Old Ullenwood Lodge

Design, Access, Sustainability &
Heritage Statement

4.0 - Pre-Application Feedback & Design Development

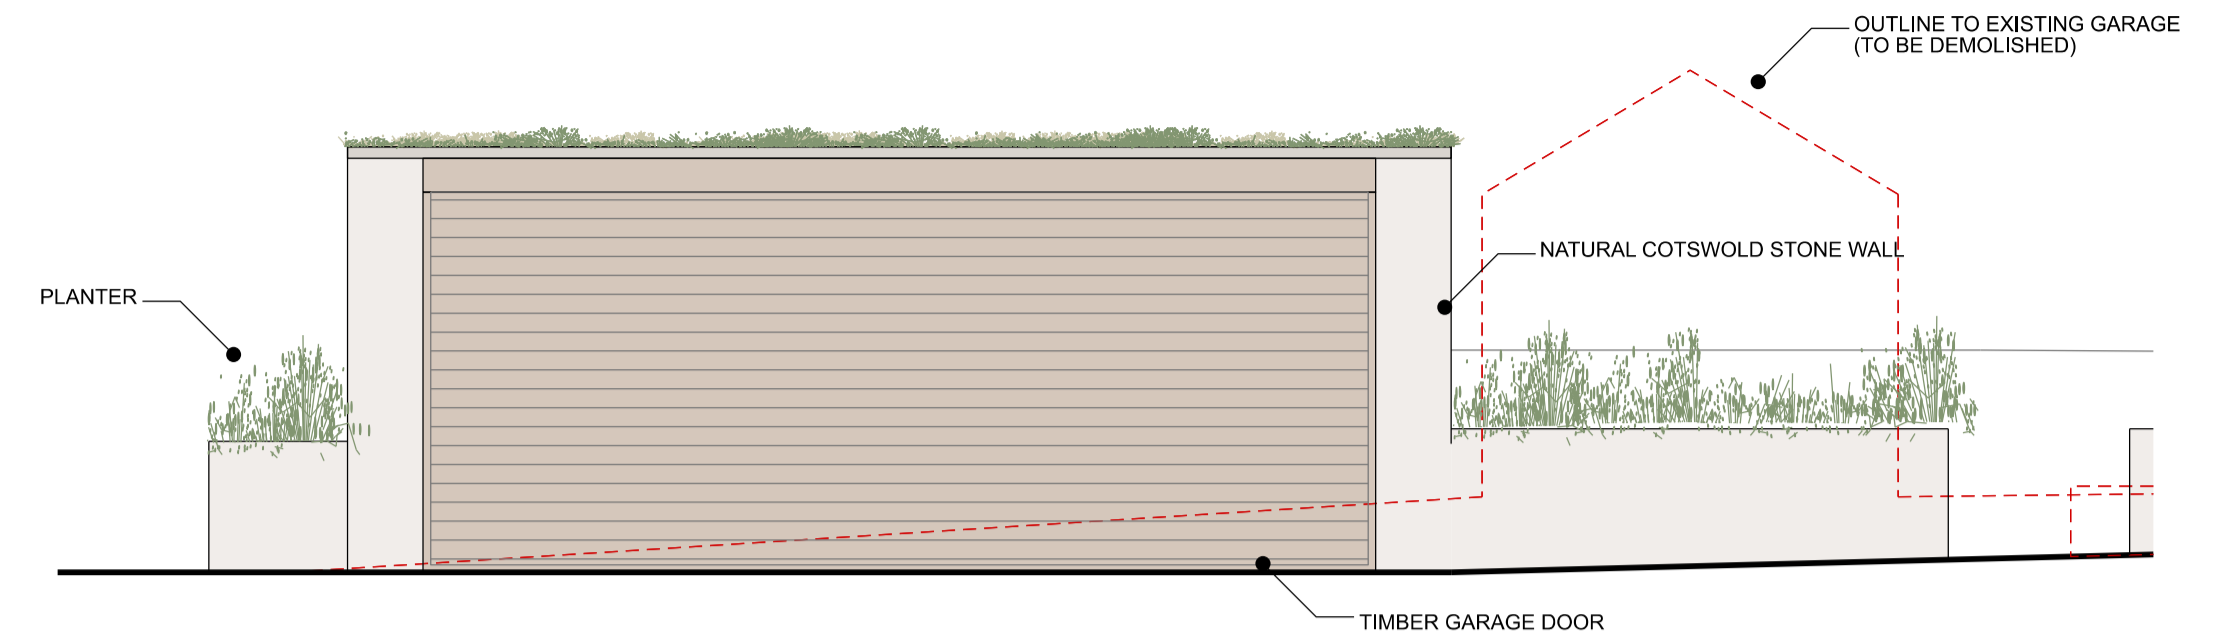
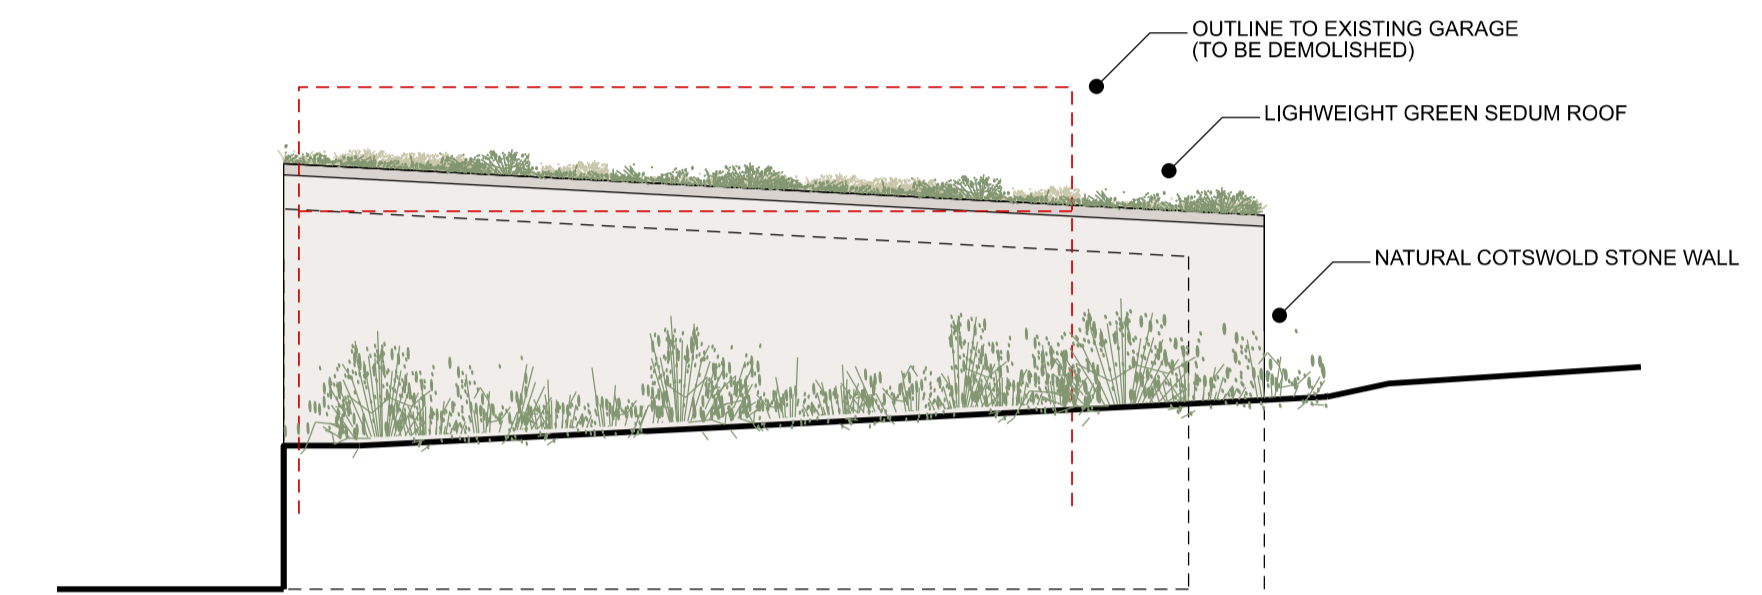
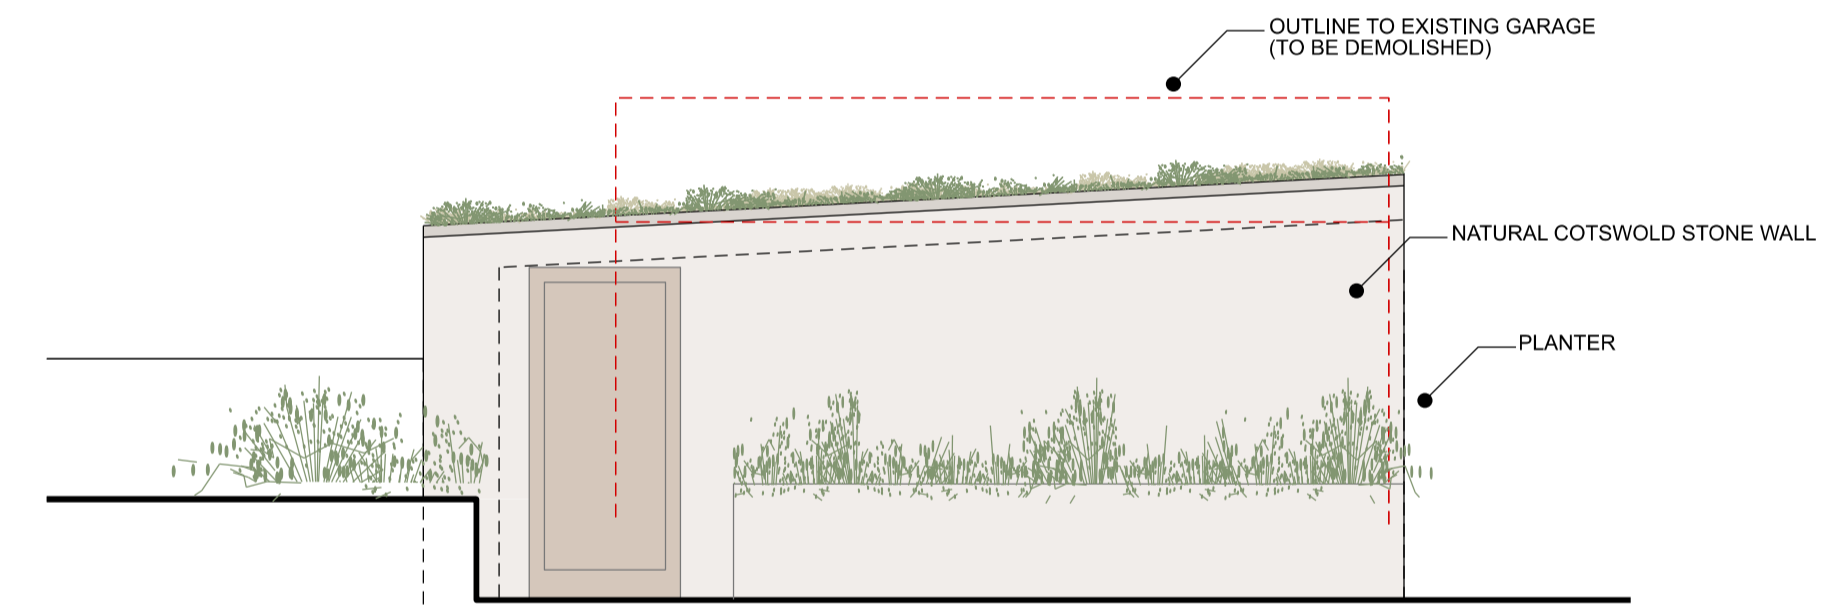
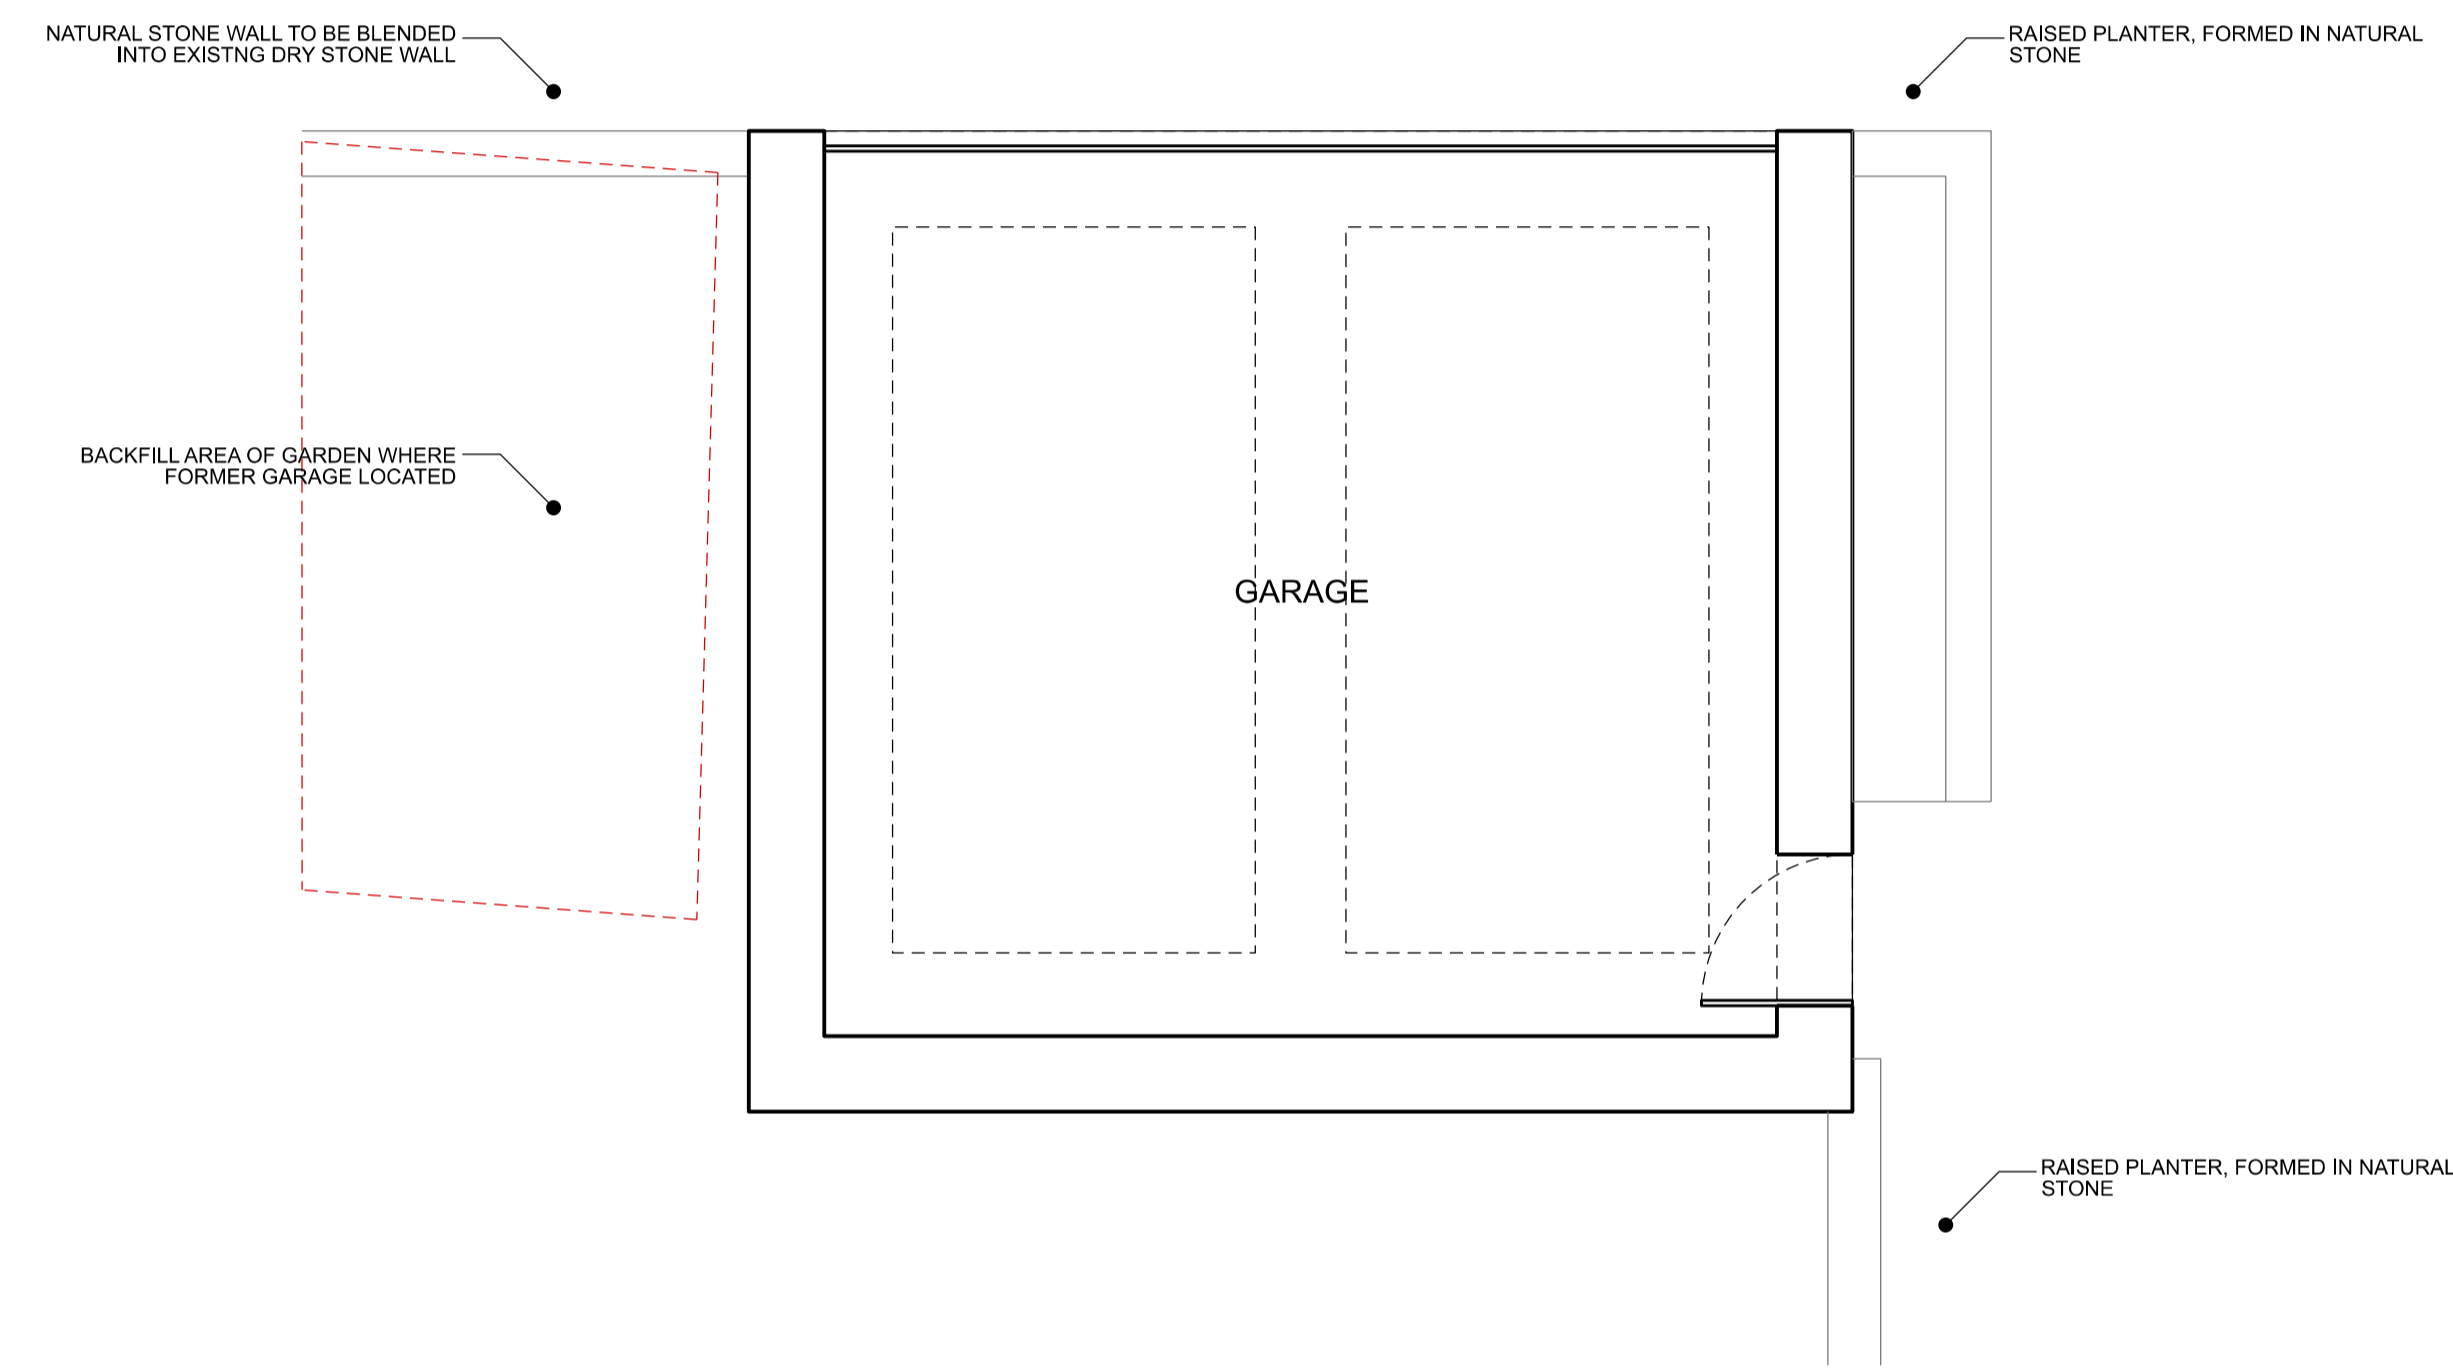
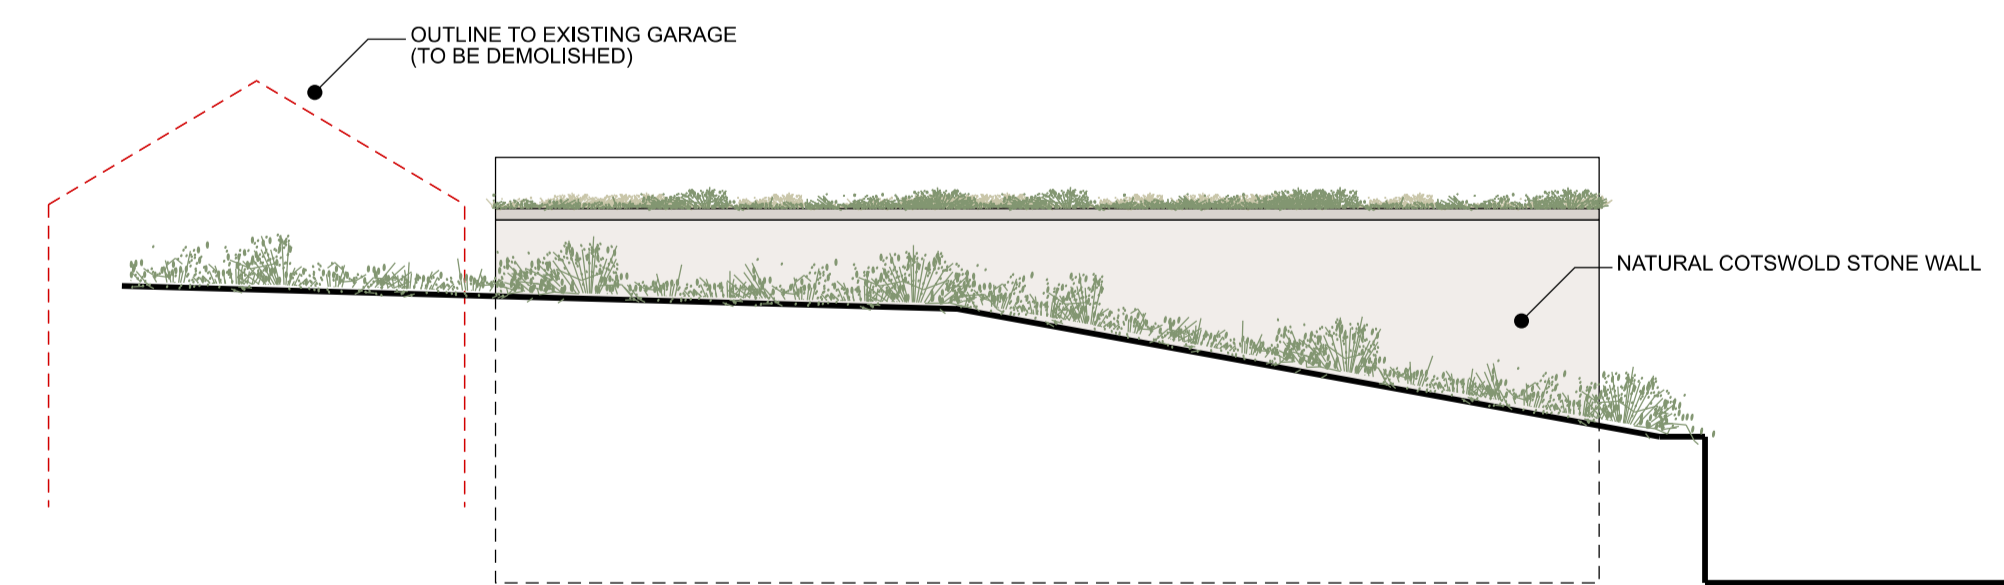
- *The proposed replacement garage is to be relocated, the existing is dilapidated single storey timber structure and its loss is not objectionable. The replacement is a double garage and the scale could be dominant in the context of the host building. If this can be suitably set into the bank and landscaping and be of minimal in its visual appearance there are no objections. As a suggestion would stone to the primary entrance elevation work here to provide a structure akin to a boundary wall and therefore less prominent?*

The garage has been redesigned in natural Cotswold stone to give the appearance of the garage forming part of a boundary dry stone wall and therefore less prominent on the site. The garage provides x2 parking spaces and is suitably sized for the property and size of the site.

A lightweight green roof softens the appearance of the garage, merging the roof into the surrounding garden. A low flat roof further helps to reduce the prominence of the garage, providing a simple single storey structure. Surrounding planters and the form of the existing garden will further soften the appearance of the garage as a subservient structure to the main house.

Tel/fax 01285 760700 Email roger@gransmore.co.uk		drg. no.	874-00-00-110	rev A	A	08.11.23	Planning	
		date	08.11.23	title	Proposed Bin Store & Bat Roost	B	14.11.23	
				scale	1:50 (A1) 1:100 (A3)	C	15.11.23	Planning

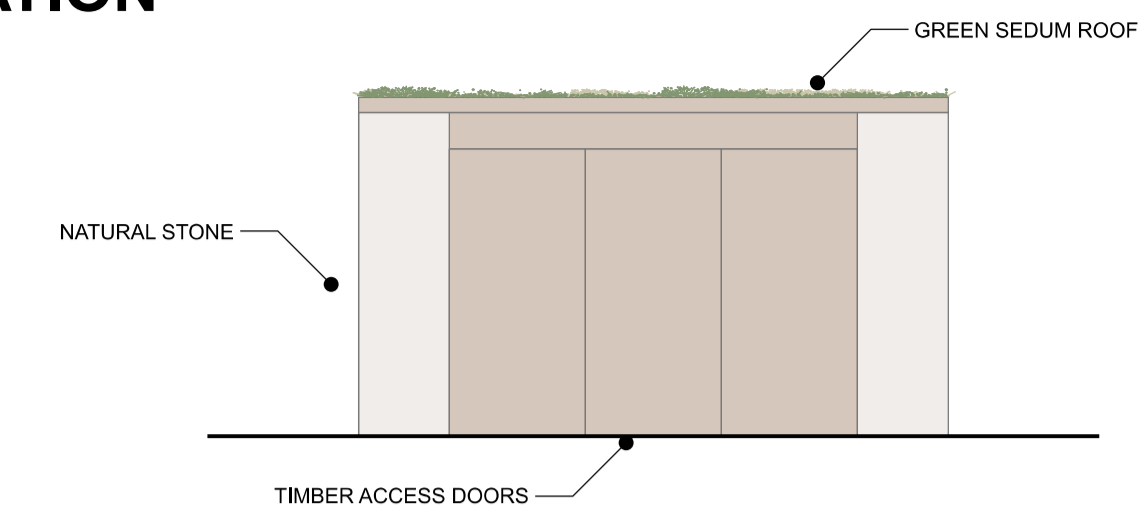
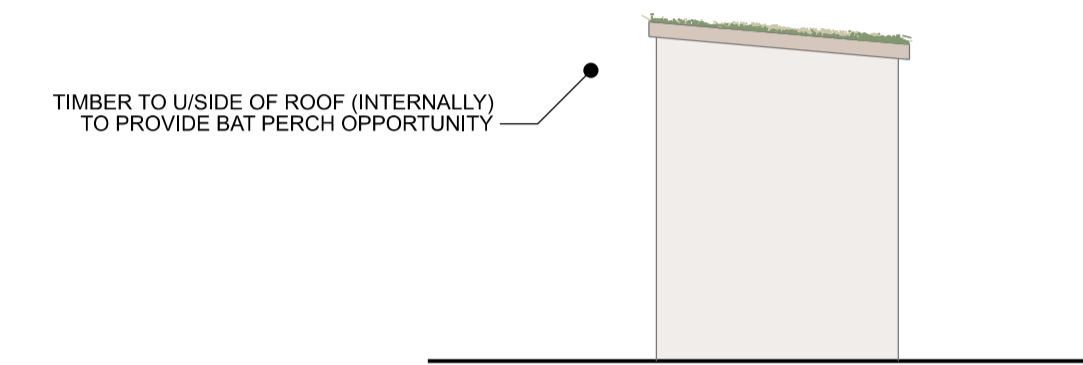
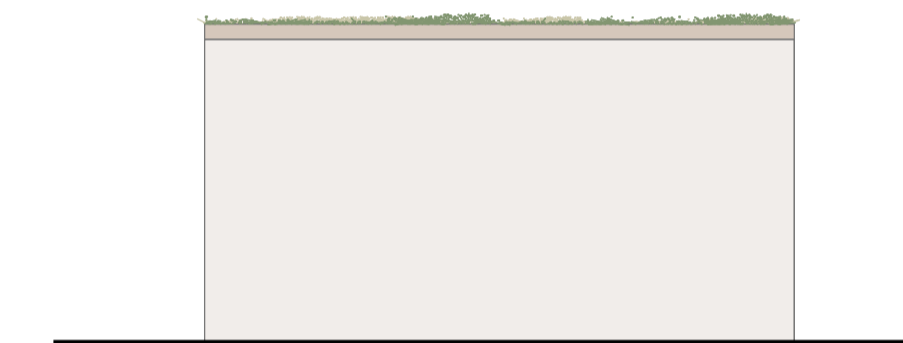
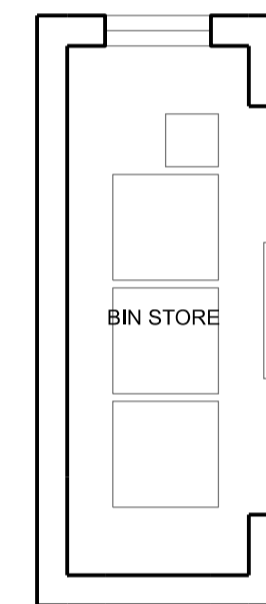
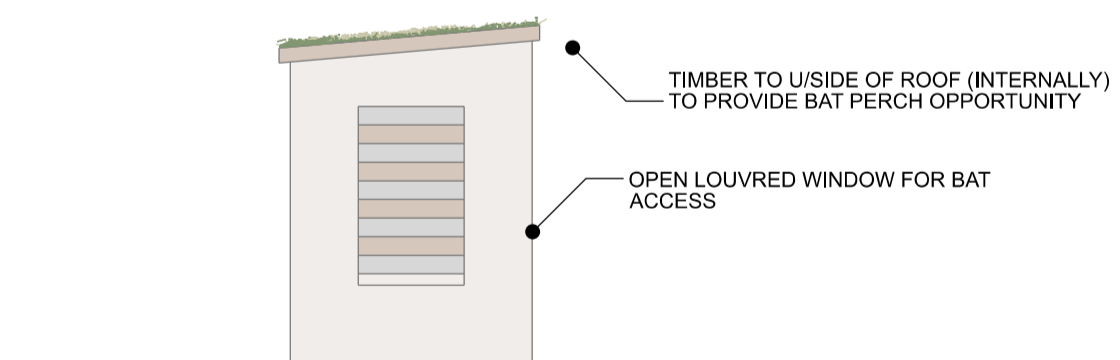
The modest nature of the building contributes to its character and significance, and while it has been extended with a two storey gable, it has retained this character. The addition of a further two storey extension is of concern as the proposals would dominate the existing host building and would fail to be subservient to it. The loss of the dormer window would be regrettable as this is a well detailed architectural feature and the extension would also obscure the feature mullion window above the modern porch.

- The proposed re-cladding of the existing re-constituted stone mock vernacular extension also requires review. While this section is re-constituted stone, the colour and form does blend in with the host asset in views from the road, and is therefore is not an intrusive addition. Timber while can be used in contemporary developments, as noted with the nearby Ullenwood Court, it is questioned in this instance. The cladding of the existing extension would result in this appearing visually prominent rather than subservient as present. Instead a traditional response should be considered, with re-cladding in natural stone preferred, potentially with elements of rough cast render. Use of painted timber, given there are sections of this elsewhere on the property, was discussed, but is considered excessive if it were to be used as cladding overall, although drawing in some elements of this could be acceptable, but would need to be carefully considered.*

- *As an approach, it is considered a more traditional approach would be required than the contemporary approach currently sought. As part of this, whilst larger areas of glazing at ground floor would be acceptable, the first floor windows should remain modest in size. It is noted that the windows and cills are not of interest or high quality in this addition and some simple changes here could approve this external façade. The terrace around the building appears awkward and exaggerates the scale and dominance of proposed and existing extension. It also results in the further prominence being drawn away from the existing entrance to the dwellinghouse. Any application should be submitted with details of any landscape changes around the site and changes to access the basement.*

The design has been substantially reduced in scale to a single storey design.

The proposed design is subservient to the original house, which remains dominant on the site. The three storey form of the mock historic extension is screened by the new entrance steps, reducing its prominence, to create a more proportionate relationship to the original house.

The new single storey extension shares the same roughcast render finish as the re-clad mock historic reconstituted stone extension. Overall, this gives a unified contemporary approach which adopts traditional materials to create a simple and clear aesthetic. This directly addresses the negative impact of the reconstituted stone areas, transforming its appearance. This will create a clear distinction between the original house and the new alterations and extension to the property. In this sense it will enhance the prominence and presentation of the original house in long range views. This gives a clarity to the property and its architectural design.

The approach outlined above recognises the need to address the appearance of the low quality existing windows/doors within the reconstituted stone extension. This is also confirmed in the Pre-Application feedback. The ground floor windows are enlarged to form a glazed corner detail, with glazed doors opening the view to the garden. This provides views to the north and east, while providing a simple yet elegant solution which complements the single storey extension. The glazed corner will be a distinctive, creative and high quality architectural feature within the
